An
Bord
Pleanála

Inspector's Report

ABP-312881-22

Application for substitute consent for retention of slatted tank, animal housing which incorporates cubicle area, calving boxes, milking parlour, dairy, office, plant room, slatted feeding area, collecting area, steel uprights at feeding area and all associated ancillary works and services. This application is accompanied by a remedial Natura Impact Statement (NIS).

Name: Mr. Patick Lalor	Drawing Title: Elevations
Project: Retention Agricultural Shed	Date: Feb 2022
Location: Grennan Td., Attanagh, Co. Laois	Drawing No.: 391-RT-03
	Scale: 1:200 Area: As shown

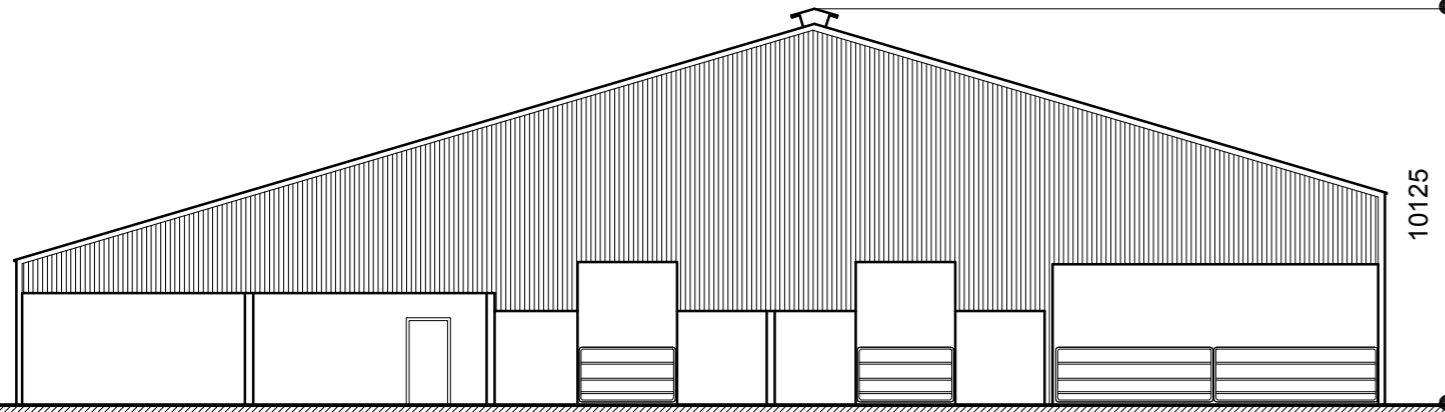
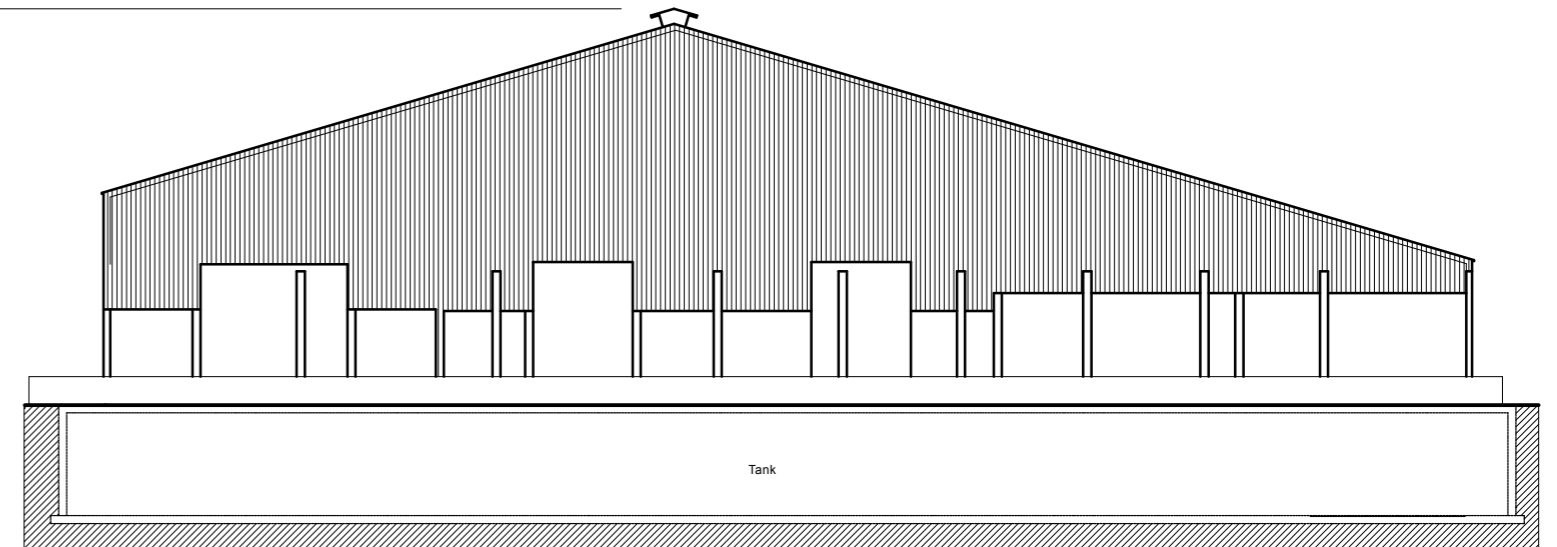
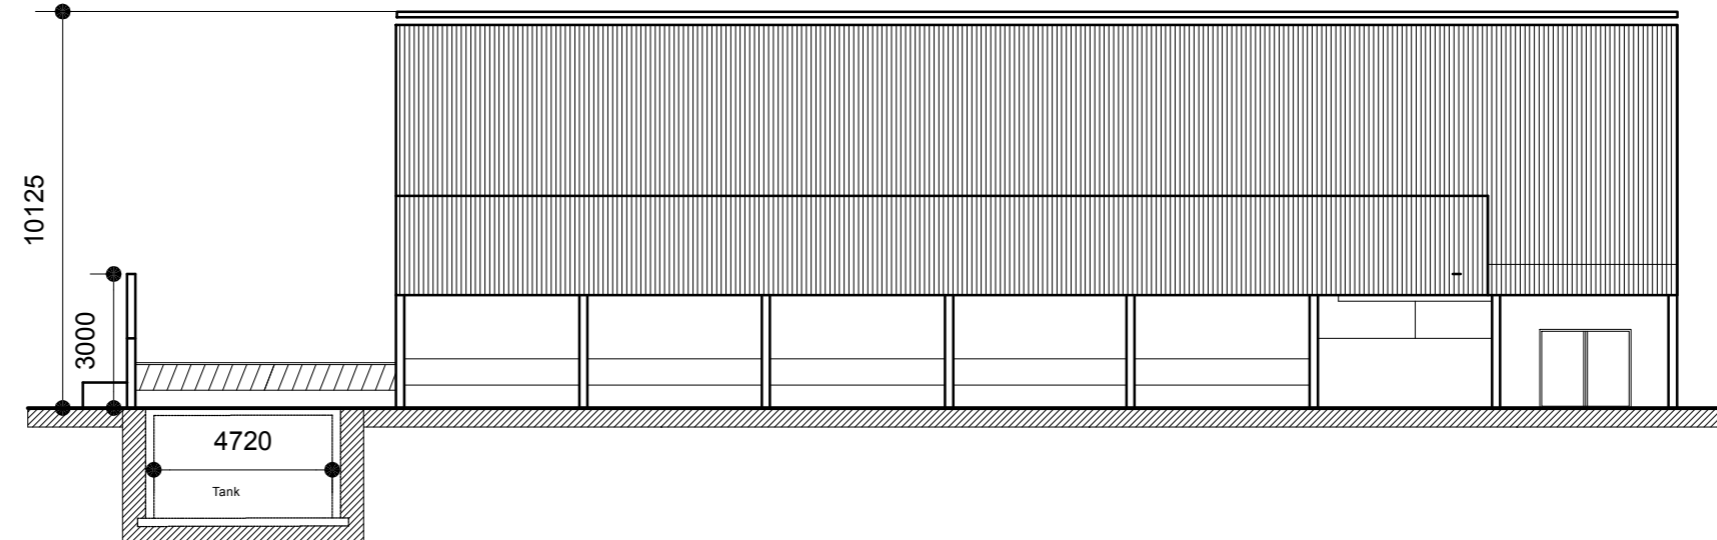
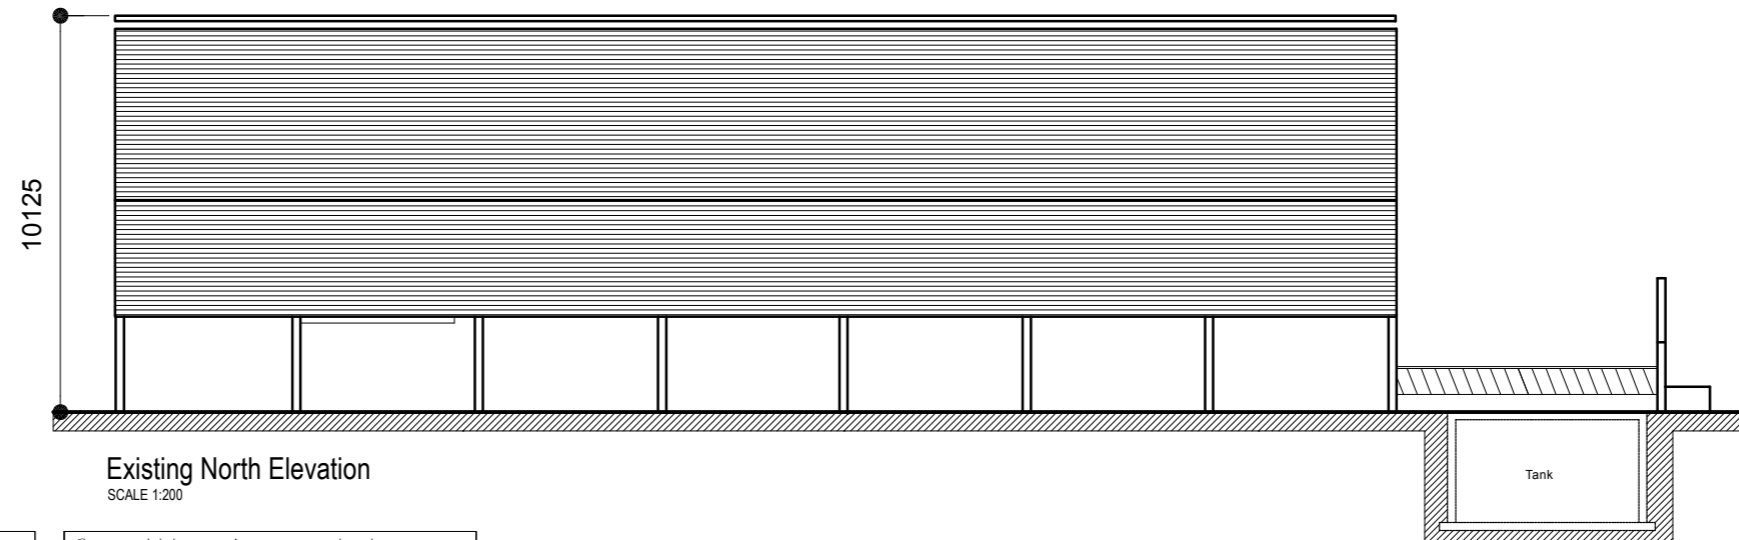
as part of the current NMP. There are gutters on the shed, but no downpipes. Remedial work will involve the addition of downpipes and the creation of a new soak pit to the north of the shed. The soakpit will provide appropriate attenuation and discharge to groundwater.
